Our ref: NE/2011/111405/02-L01
Your ref: N6/2010/3120/DC3
Date: 3 June 2011

Splashlands, Stanborough Road, Welwyn Garden City.

Redevelopment of site to provide a wet play area, adventure play areas, an educational play area, high ropes attraction, changing huts, education room, cafe and toilet facilities. Additional information.

GENERAL SITE AREA DRAINAGE LAYOUT PLAN

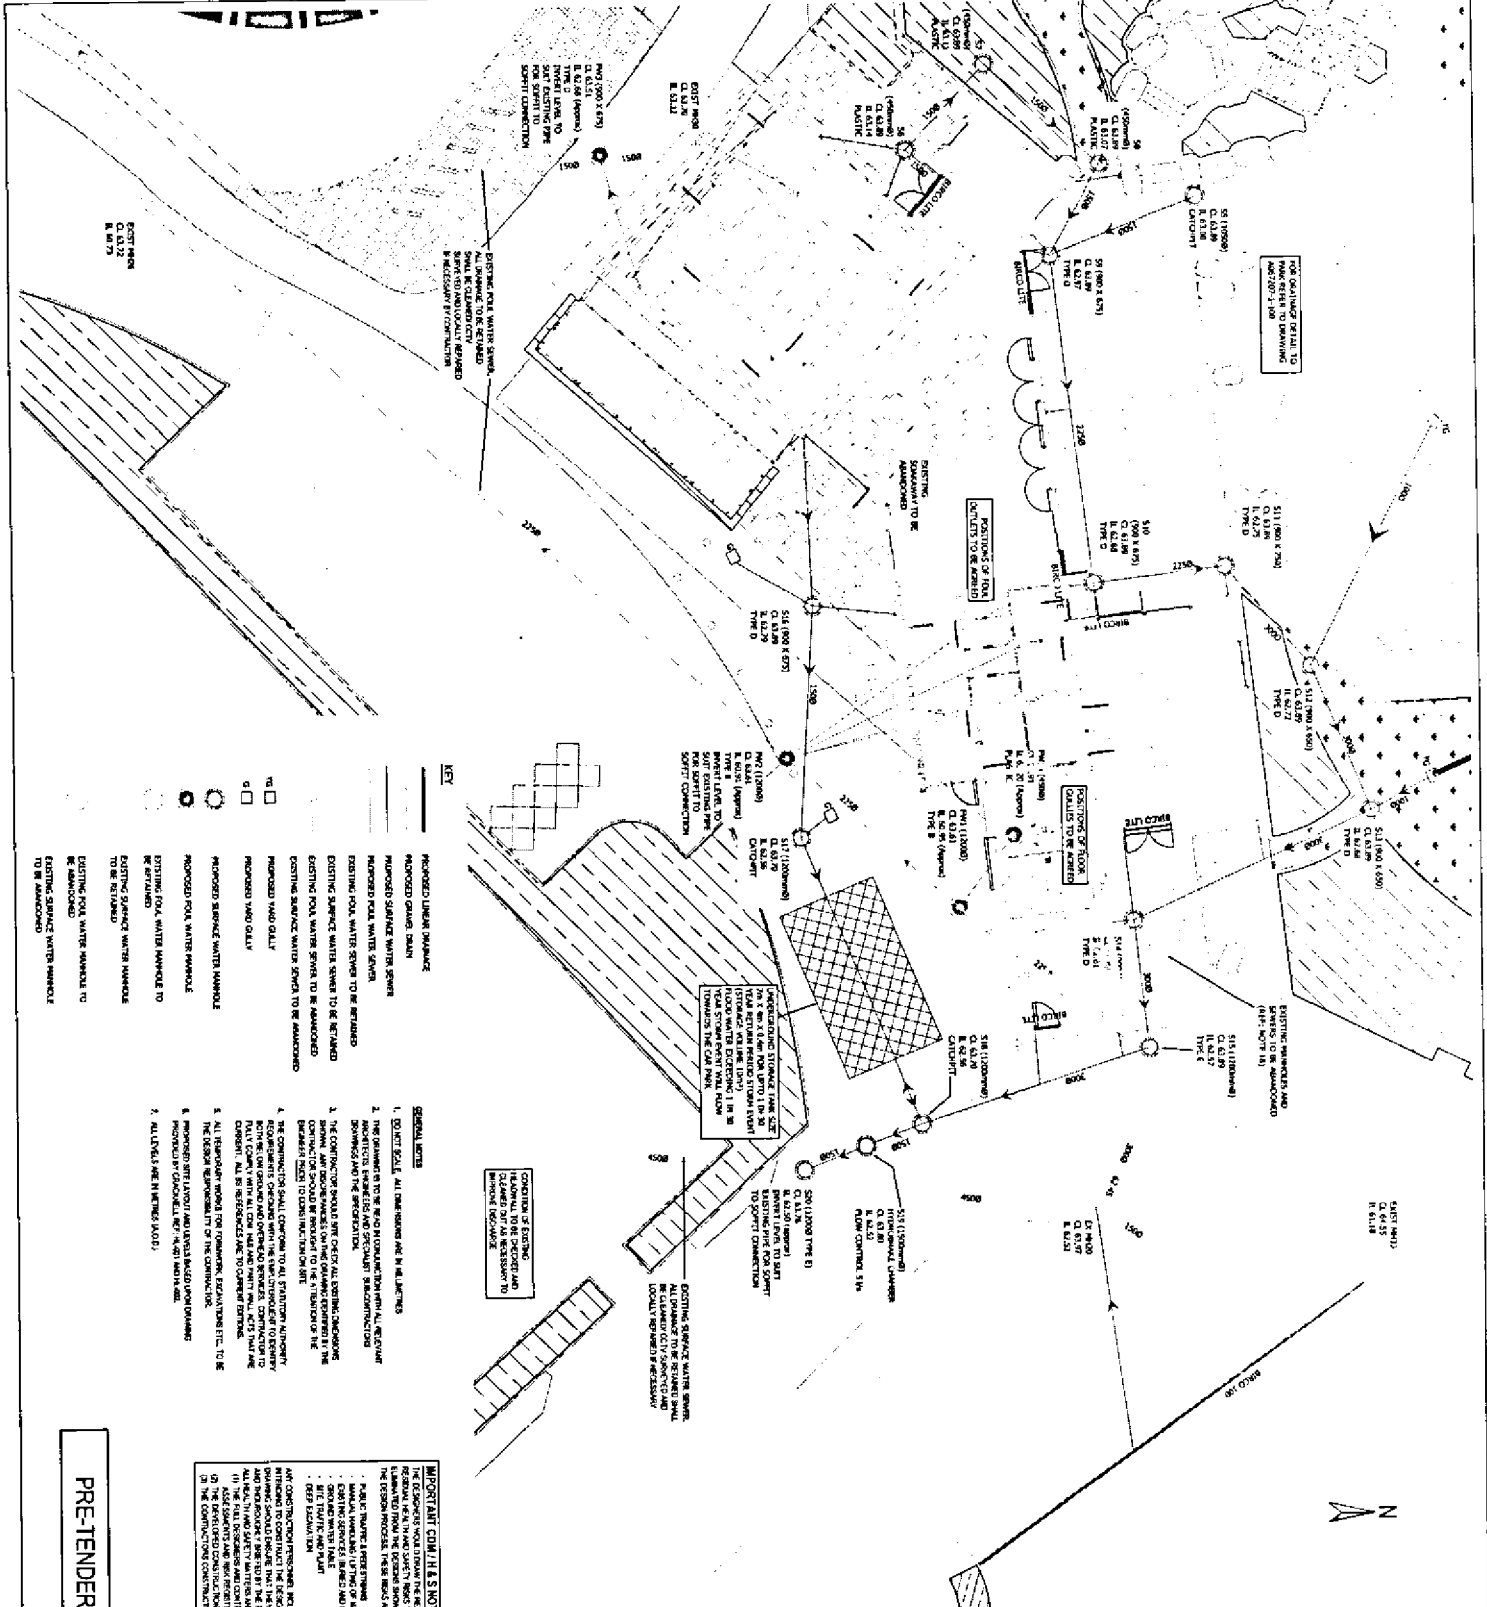
Drainage drawing 100A appears to show swales draining to ground. If this is the intention we will need to see some infiltration testing to support this design. It is unclear whether this system will work given that your letter states that high groundwater levels limit the use of swales.

We would suggest that using lined ponds or swales and connecting them to the drainage system would avoid the difficulties with infiltration and provide a sustainable scheme by removing the need for an underground tank. We request that the applicant investigates this further. Green roofs were also previously proposed for this scheme during earlier discussions. It is unclear why these have now been removed from the scheme.

PROPOSED EARTHWORKS & FLOOD COMPENSATORY PLAN
 SCALE 1:200

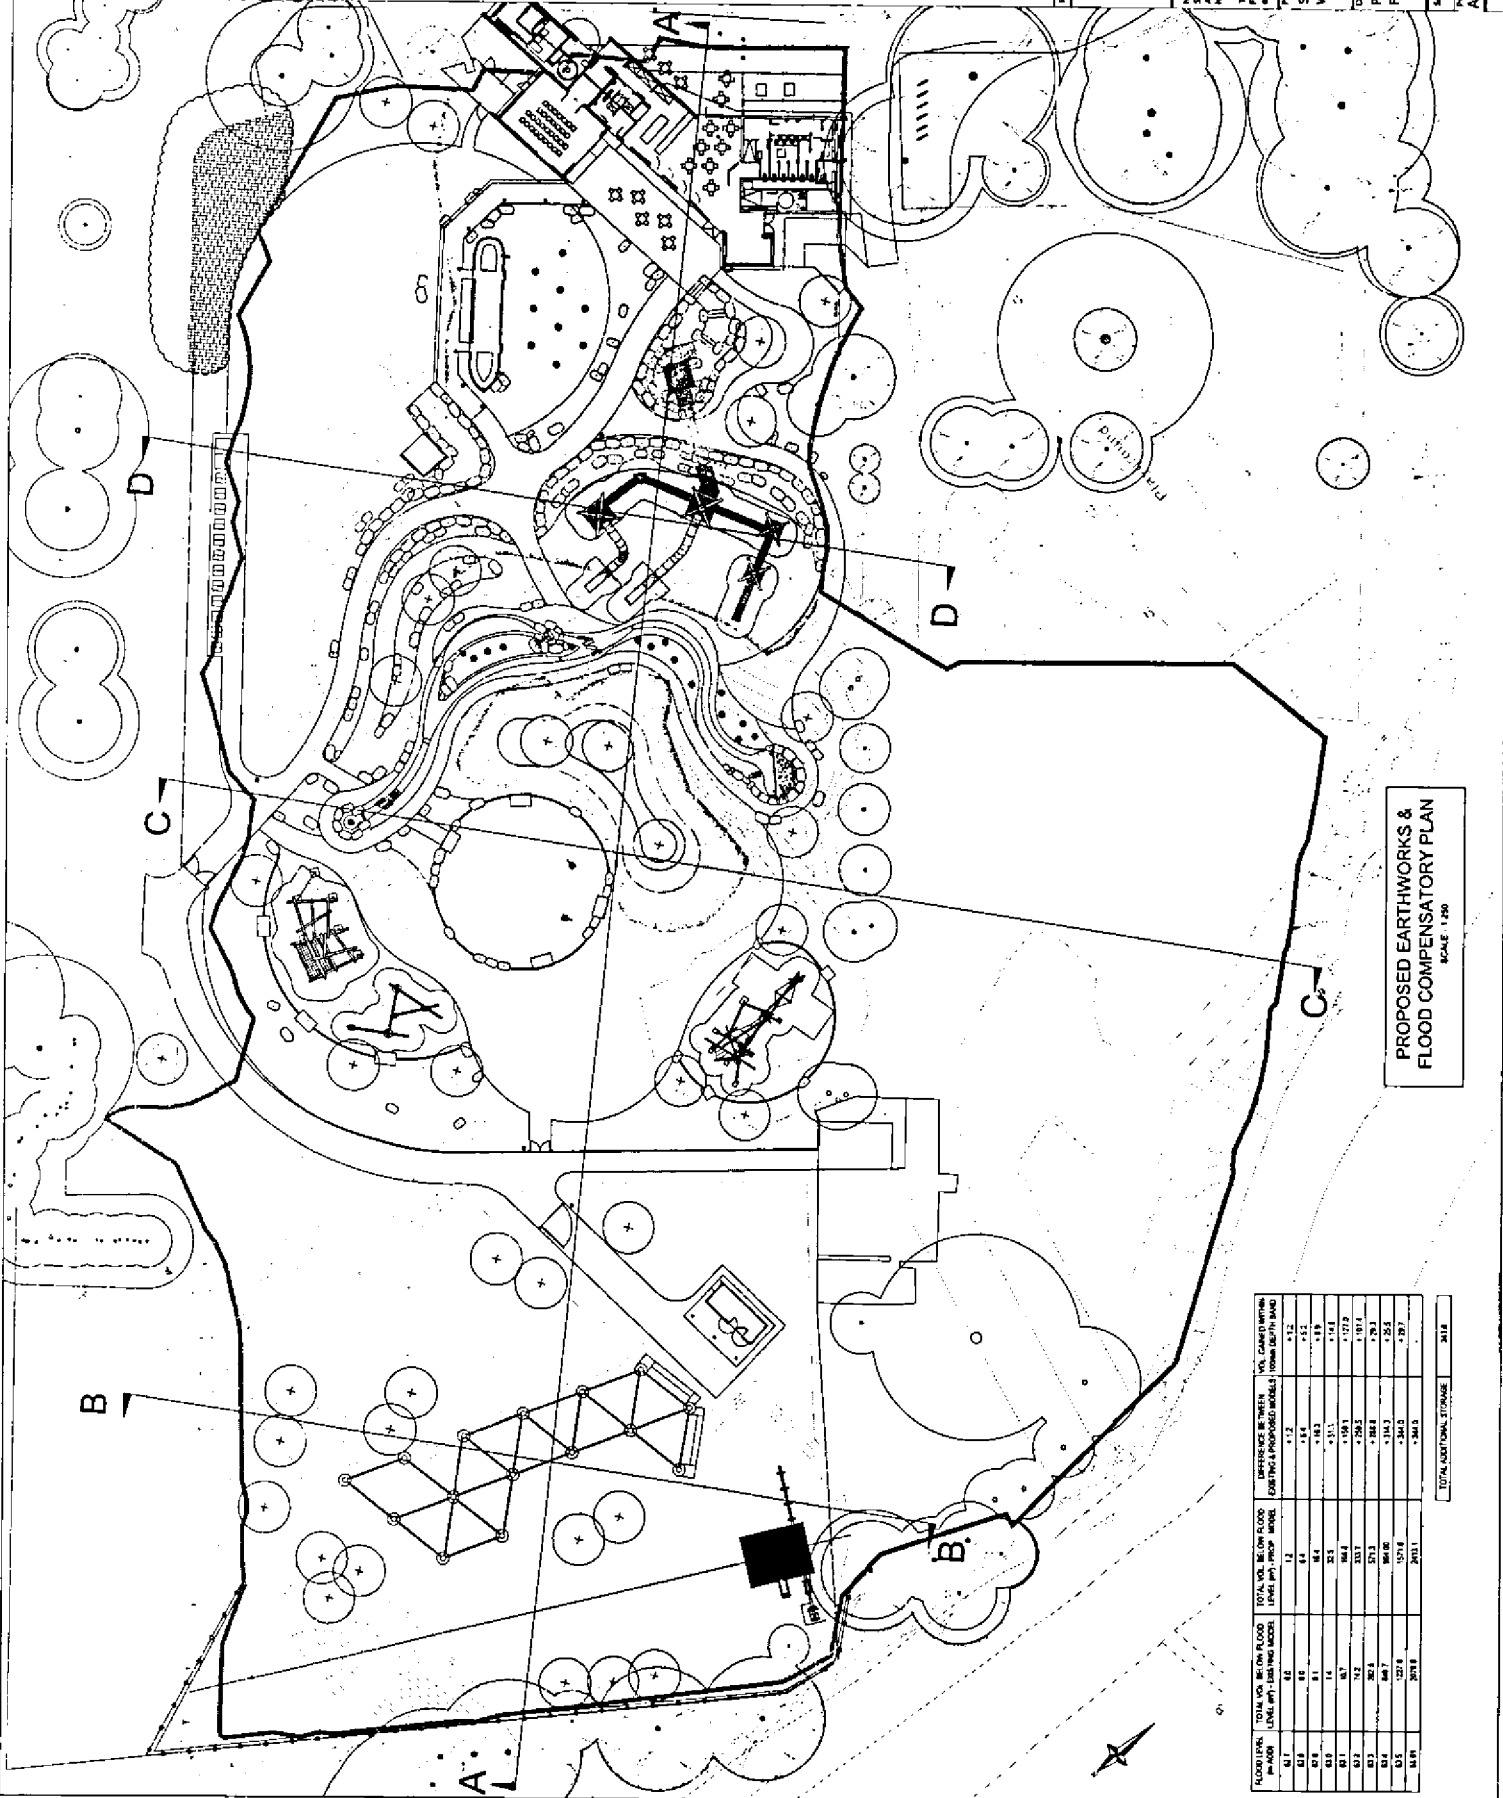
Based on the FRA addendum SM/RW/A067207 dated 20 May 2011 and drawing 122 Revision A we are satisfied with the details provided on the floodplain storage compensation scheme. We would be happy to request a condition securing the details of this once our other outstanding queries have been addressed.
